Development Facilitation Team (DFT) – Review Comments

DRB Project No: PR-2023-008235 Date: 4/10/2024 Agenda Item: #3 Zone Atlas Page: L-15

Legal Description: Tract 1-B University Village

Request: Subdivide One Existing lot into 2 new lots

# WAIVER EXHIBIT

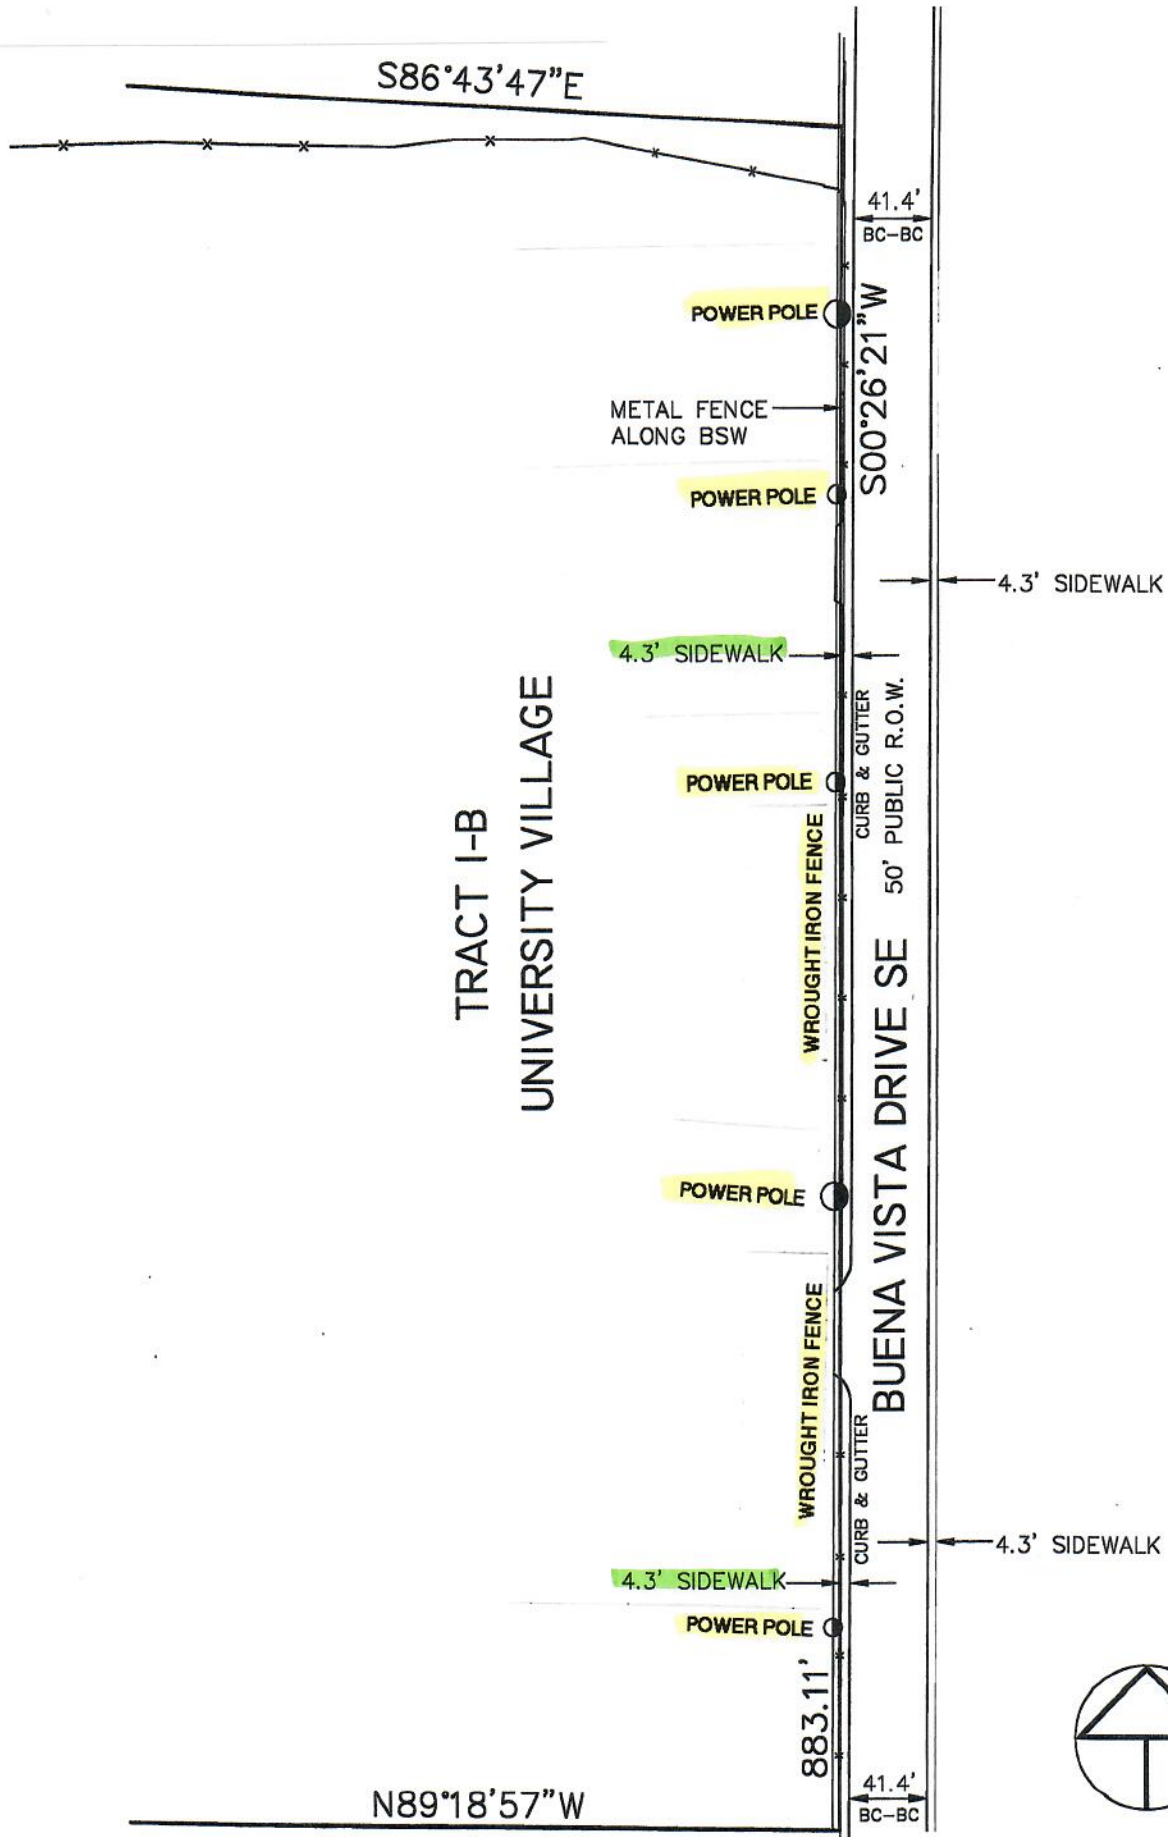
1. University is a Minor Arterial and requires 6' sidewalks with 4' around any obstructions and a 5-6' Landscape buffer. Eastern and Buena Vista are Locals and require a 5' sidewalk with 5-6' Landscape Buffer. Justification for Buena Vista sidewalk and buffer waiver is acceptable.
2. I see that you are proposing ROW dedication for sidewalk and buffers on University and Eastern. Please provide figures for these streets that dimensions ROW, sidewalk, buffer and curb and gutter.
3. All work within the ROW needs to be placed on an infrastructure list and completed through the work order process.

- Confirm/discuss the compliance with **Section 7 of the DPM Table 7.2.29** and Required Improvements section from 5-4(N) of the IDO. *Regarding Sidewalk width requirements and landscape buffers.
Verification of standards per Transportation
*University is a Minor Arterial and requires 6' sidewalks with 4' around any obstructions and a 5-6' Landscape buffer. Eastern and Buena Vista are Locals and require a 5' sidewalk with 5-6' Landscape Buffer. *Justification for Buena Vista sidewalk and buffer waiver is acceptable.*
Proposed ROW dedication for sidewalk and buffers on University and Eastern; Please provide figures for these streets that dimensions ROW, sidewalk, buffer and curb and gutter.
